Subject: FW: [EXTERNAL EMAIL] - RE 1513: Land Off Bristol Road, Falfield- P22/00461/F- Conditions update

From: James Reynolds <James.Reynolds@southglos.gov.uk>
Sent: Monday, July 10, 2023 8:21 AM
To: James Durant <james.durant@cotswoldhomes.co.uk>
Subject: Re: [EXTERNAL EMAIL] - RE 1513: Land Off Bristol Road, Falfield- P22/00461/F- Conditions update

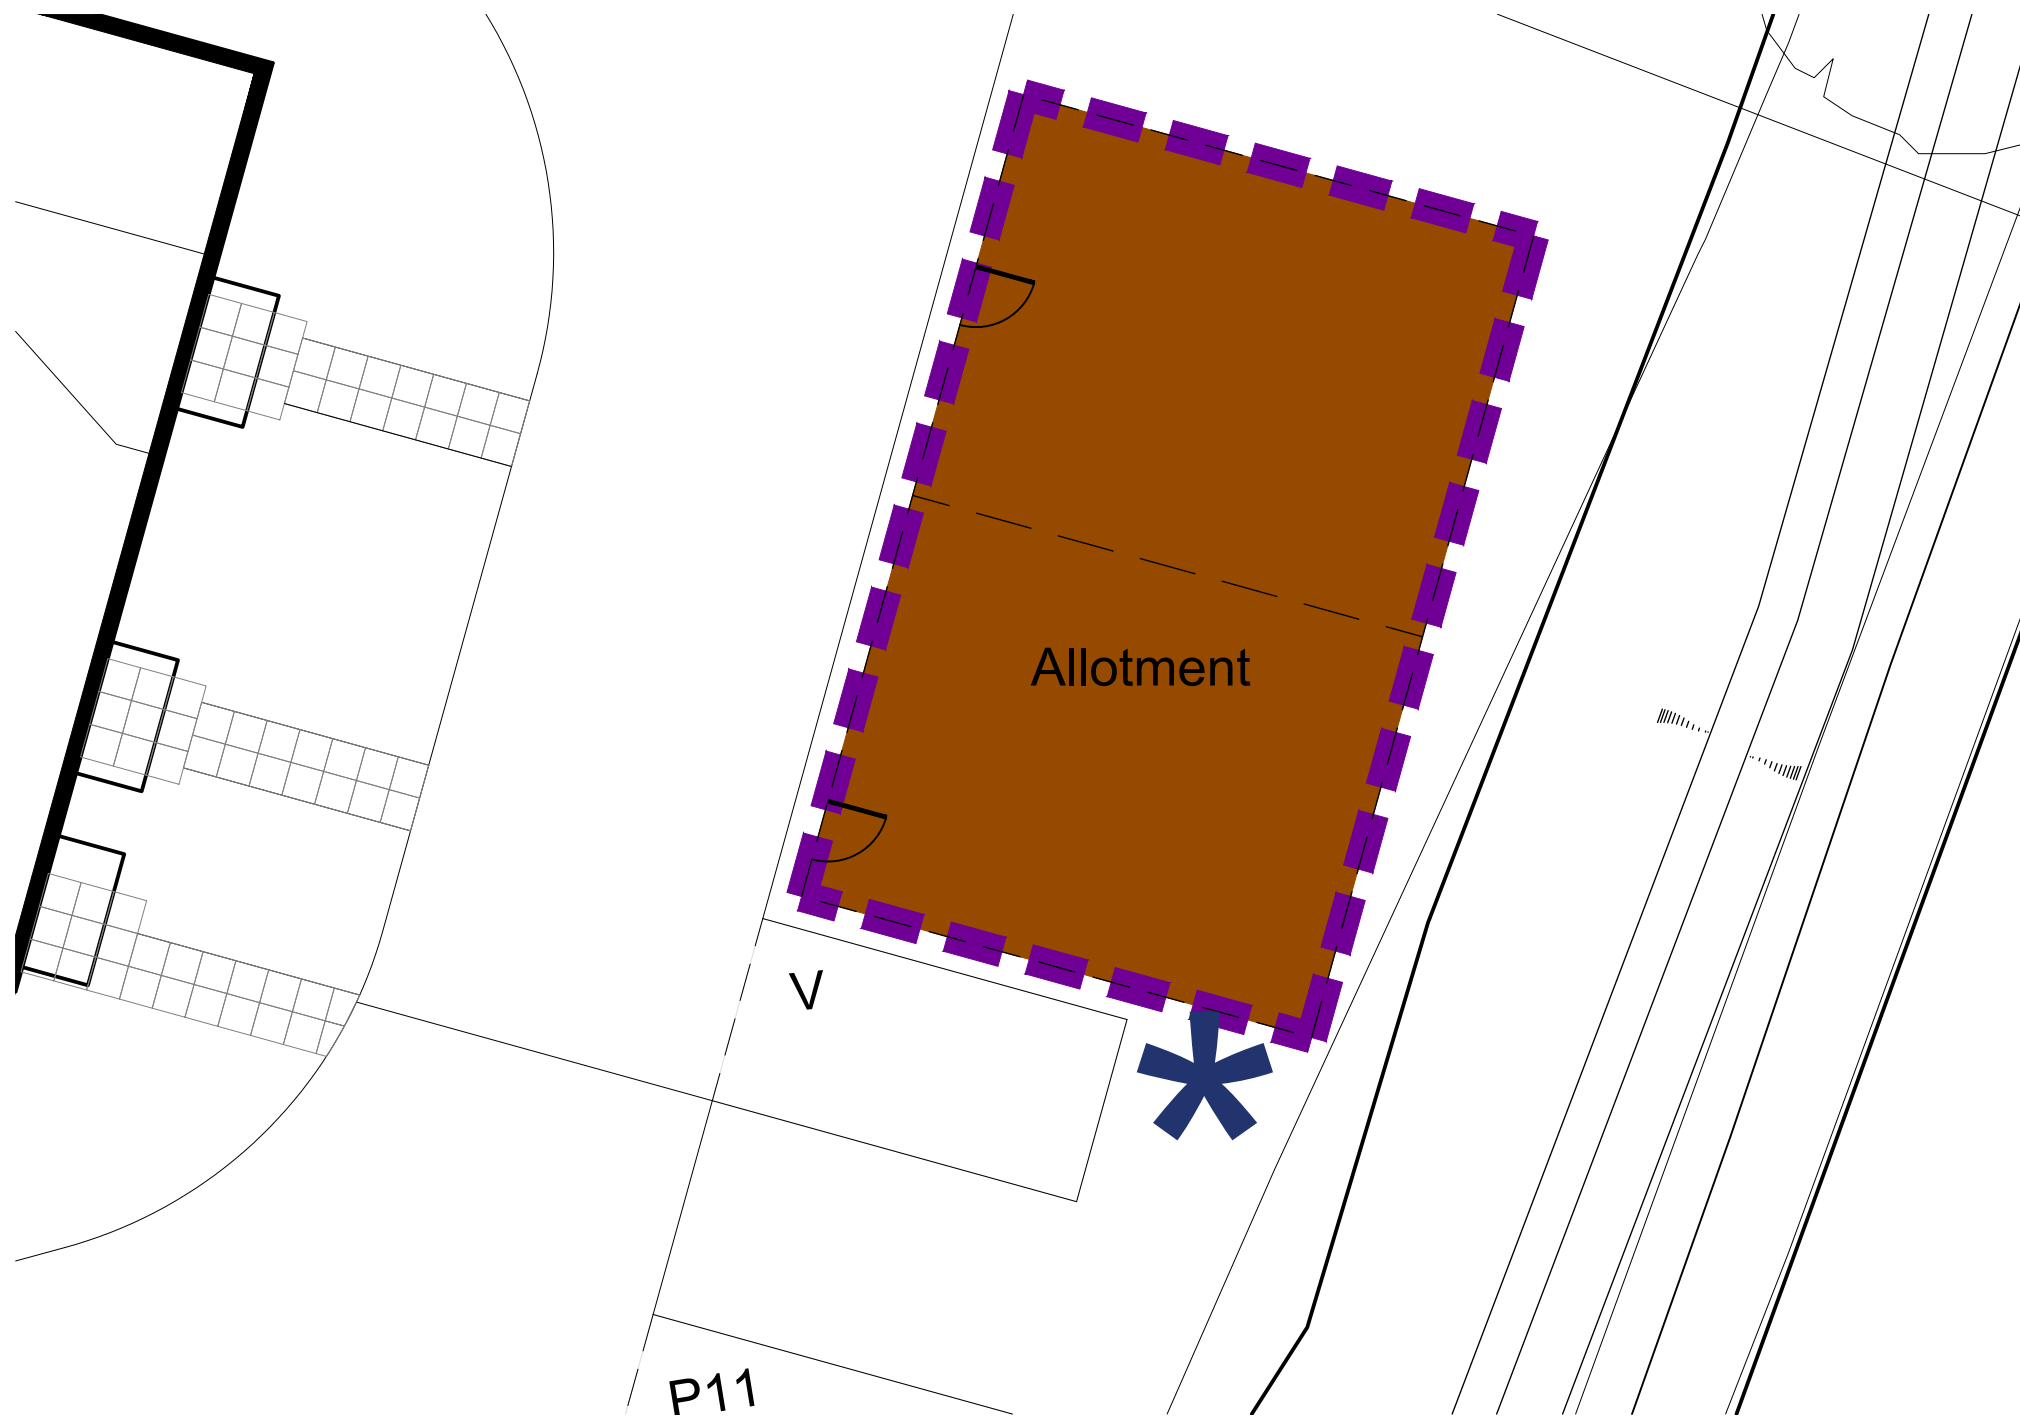
In regard to condition 6 (landscaping), the need to include this comes from advice from our legal officer and is due to the fact that we don't know whether the play area will be hard or soft landscaped? This needs to be shown on the landscaping plan to tie in with the S106. There is also some concern been raised that *Prunus laurocerasus* 'Otto Luyken' is proposed next to the play area. The leaves and fruit are harmful if ingested. So in terms of proposed planting, there would not be a great deal of changes needed from that previously agreed. The new landscape plan would only need to amend the harmful plant next to the play area and include the surfaces for the play area/allotment. I am therefore minded to keep condition 6.

I will though also include an additional condition for the allotments, as currently we do not know how these will be operated. e.g., as a community style allotment or mini allotment plots for individual letting.

Prior to the commencement of the development above Damp Proof Course (DPC) level, a detailed layout plan of the allotments, as well as details of the operation and management of the allotments shall be submitted to and approved in writing by the council.
